Your Ref:
Our Ref: EP/54/12/
Please ask for:
Mr J Smith

22nd June 2012

Room in roof with hip to gable and front and rear dormers
28 Vermont Way East Preston

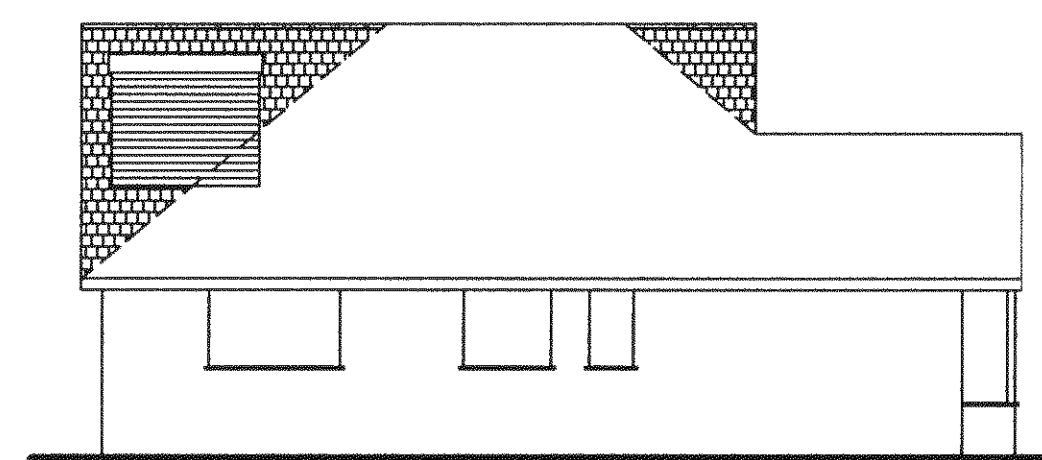
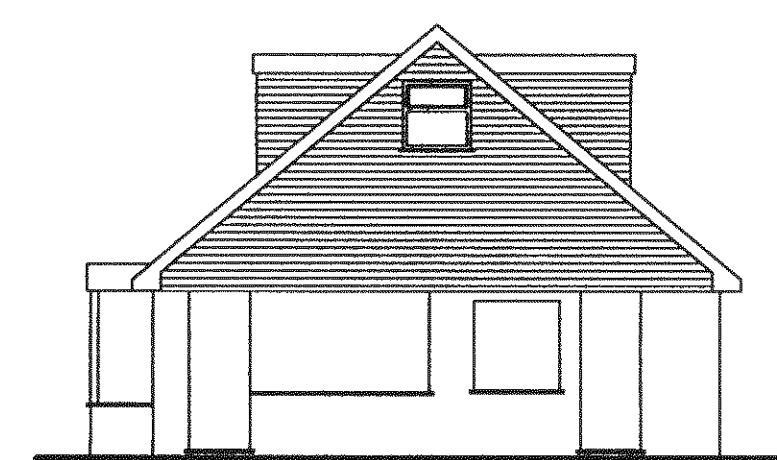
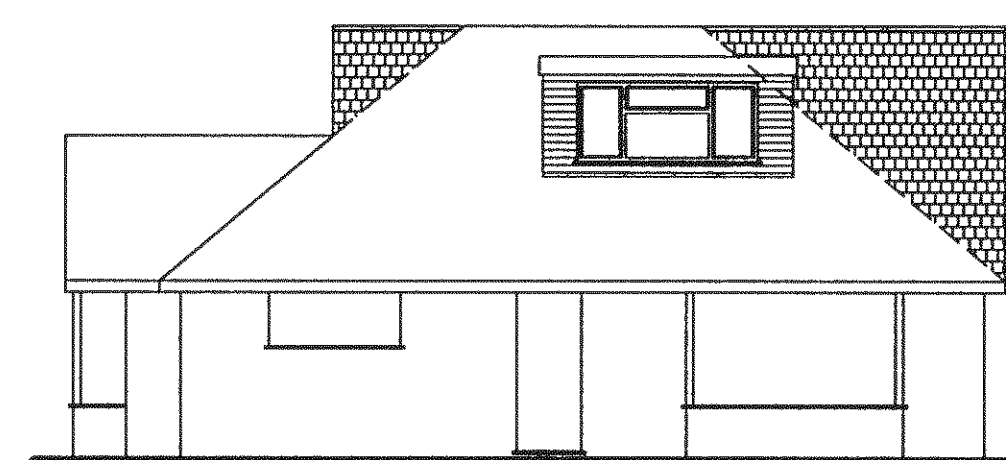
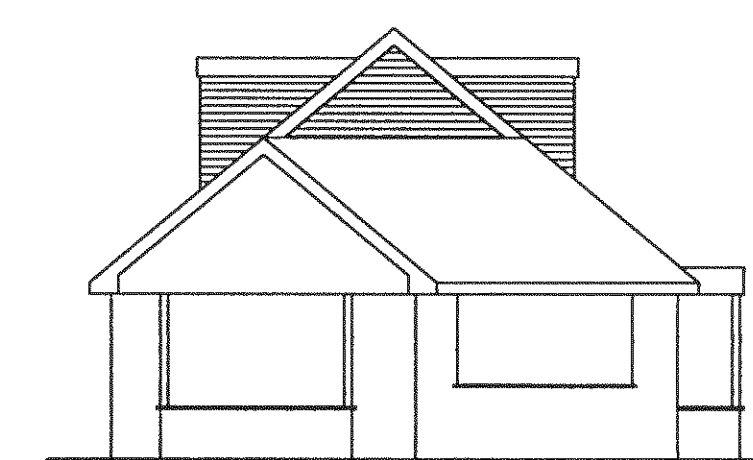
The Application is to extend the property upwards. No nearby property appears to have extended upwards and therefore this would mean that this property would no longer be in keeping with the local street scene.

The committee felt that the Application did not meet the spirit of the Arun District Council Local Plan Saved Policy DEV19 in as much as the proposed extension does not sympathetically relate nor visually integrate with the existing property. The committee felt that the extension is visually dominant to the existing property, and this is also contrary to the East Preston & Kingston Village Design Statement. The proposed extension may have an overbearing impact on neighbouring properties.

The committee was concerned about the design of the proposed extension and felt that the District Council should refer to paragraph 64 of the National Planning Policy Framework which states, 'Permission should be refused for development of poor design that fails to take the opportunities available for improving the character and quality of an area and the way it functions.'
